From: Finlay Gardner
Sent: 11 February 2020 15:47
To: chris barrow [REDACTED]
Subject: LU/370/19/PL

I have started looking at the application you have in for 49 Horsham Road (ref: LU/370/19/PL). There appear to be a number of discrepancies in the plans that I am hoping you are able to iron out for me so I can have a look at the application in greater depth and get a decision to you as soon as possible. On the site plan there is clearly a structure to the rear of the shop, then on the location plan the structure is largened with the addition of a pitch roof and connected to the shop itself (I am assuming this is the actual proposal). However, this is where I gain my first confusion, having been on the site visit there is an existing structure with a pitched roof, is this to be demolished to incorporate the larger scheme? The floor plans the add an extra element of confusion illustrating there is no current structure in the 'Yard'. Then on the elevations as

PROPOSED GROUND FLOOR PLAN.
(1:100)

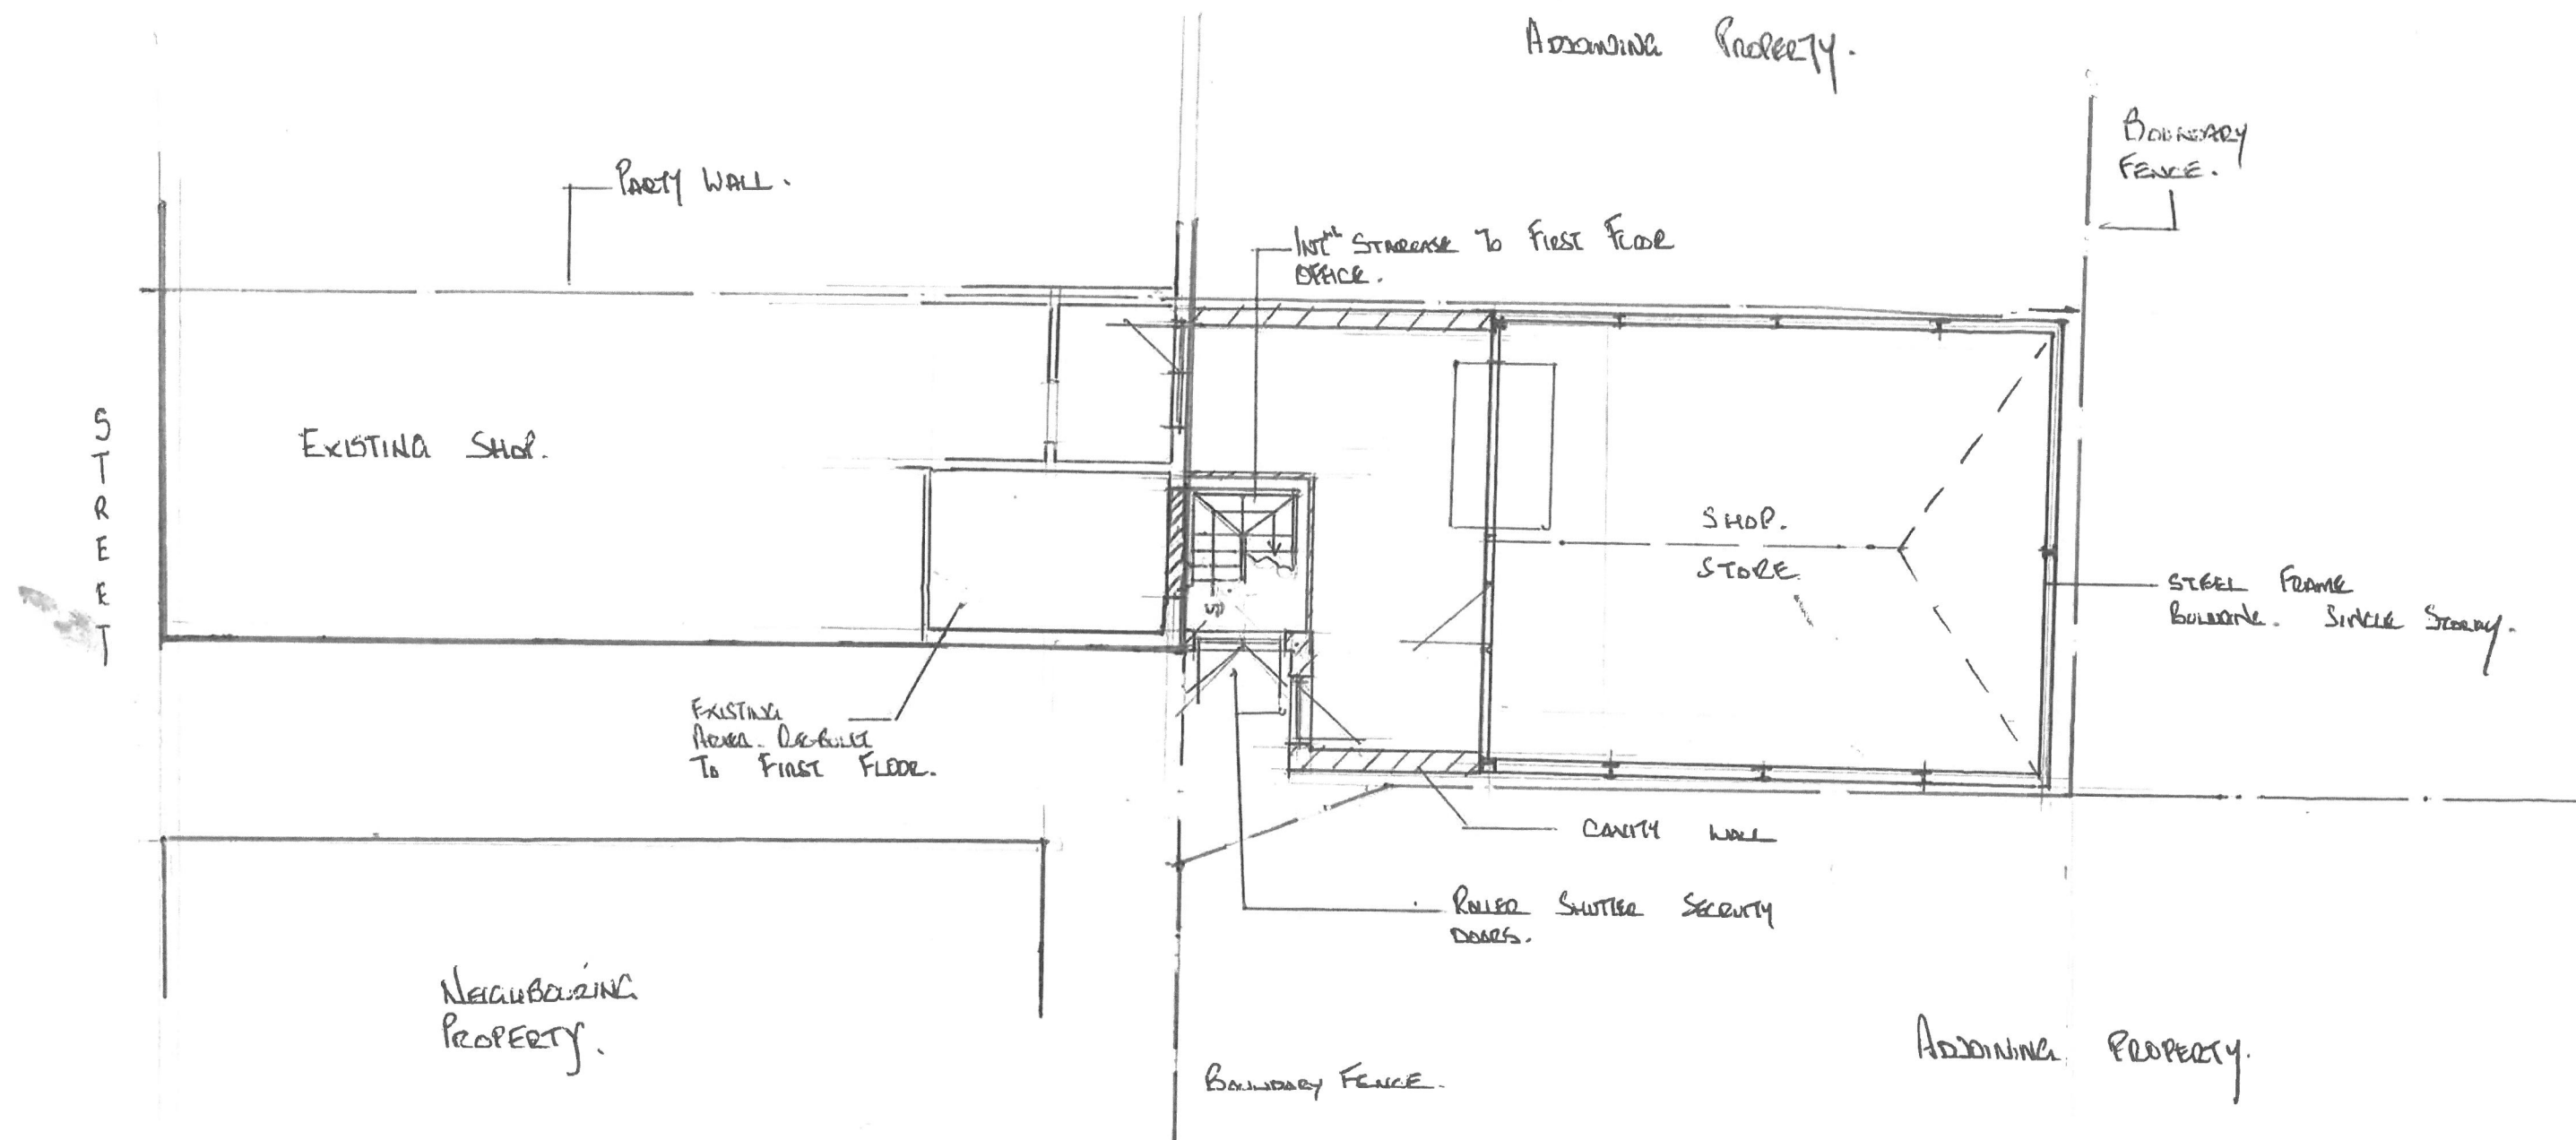
existing there is a flat rooved extension that connects to the shop and spans the complete depth to the rear. Finally the proposed internal stair case appears to be in the new single storey flat rooved rear extension leading me to be a little confused as to how that would work?
